CITY OF ALBUQUERQUE

Planning Department
Alan Varela, Director

Re: Take 5 Car Wash Express
10084 Coors Blvd NW
30-Day Temporary Certificate of Occupancy
Transportation Development Final Inspection
Architect's Stamp dated 02-13-23 (B14-D010C)
Certification dated 05-14-2025
Trans-2025-00123

SITE PLAN

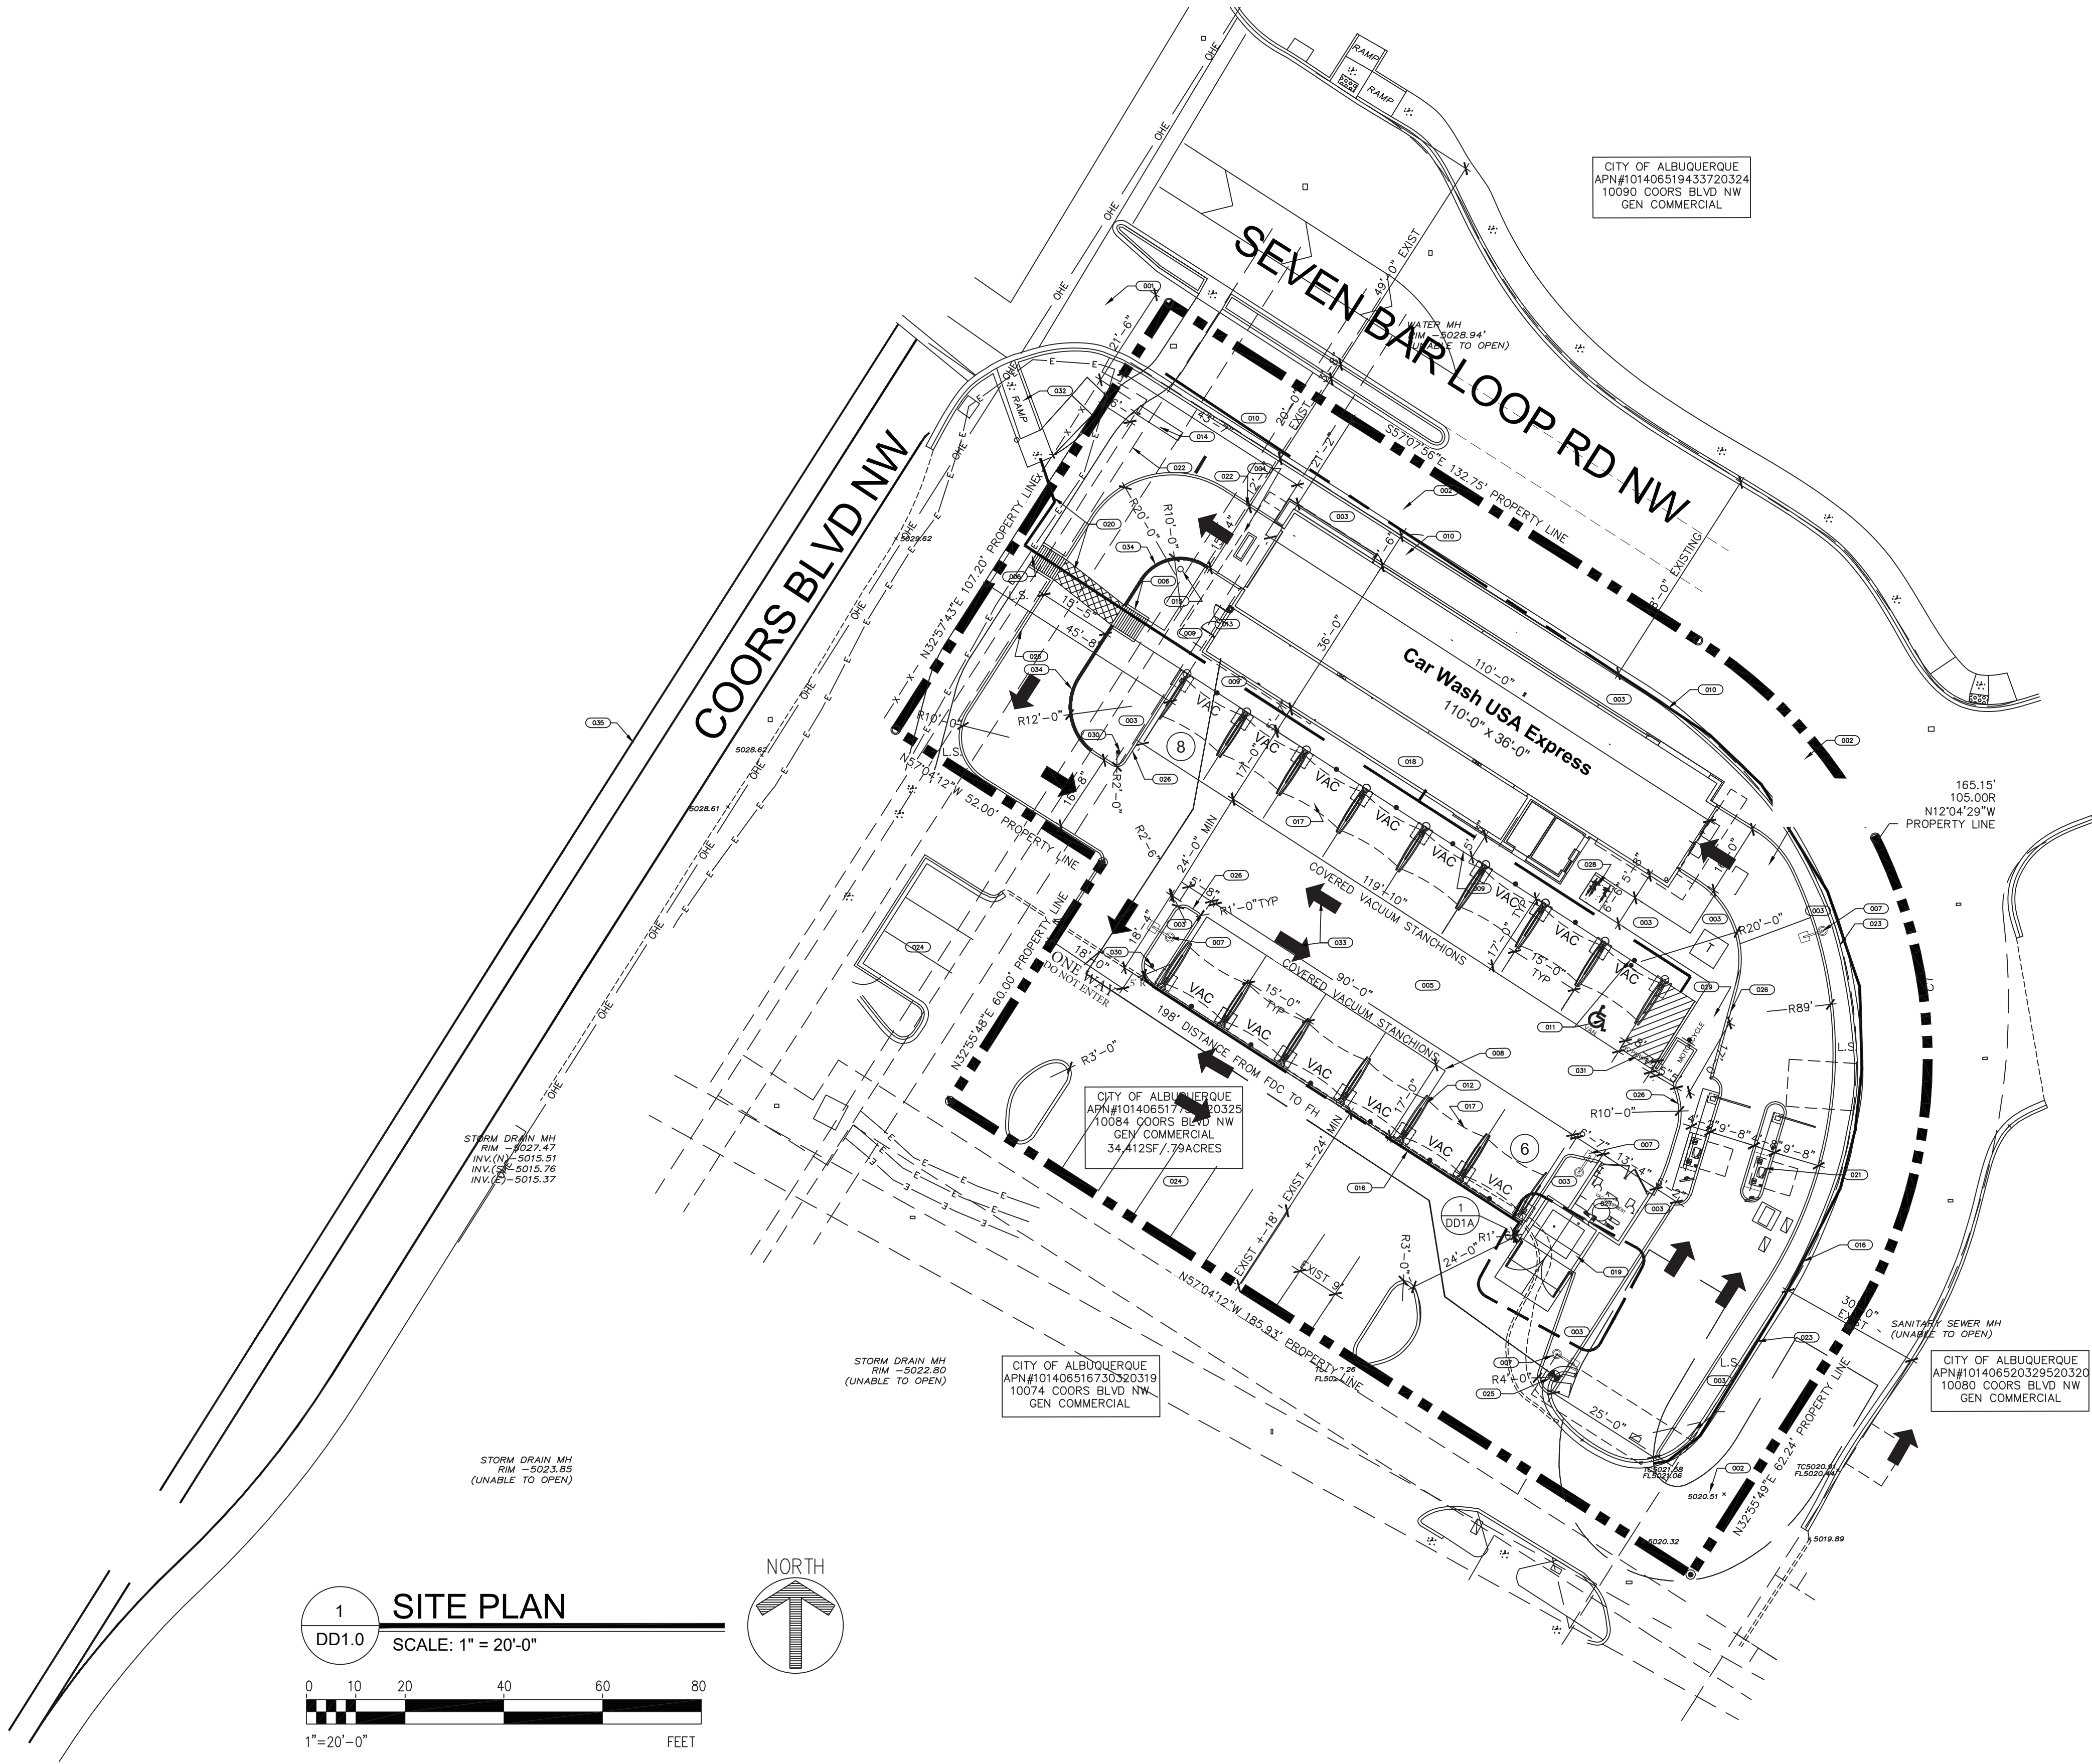
1. The work order must be completed and approved.
2. Per approved site plan and city requirement, please install the "U" shape Bike rack following the required dimensions.
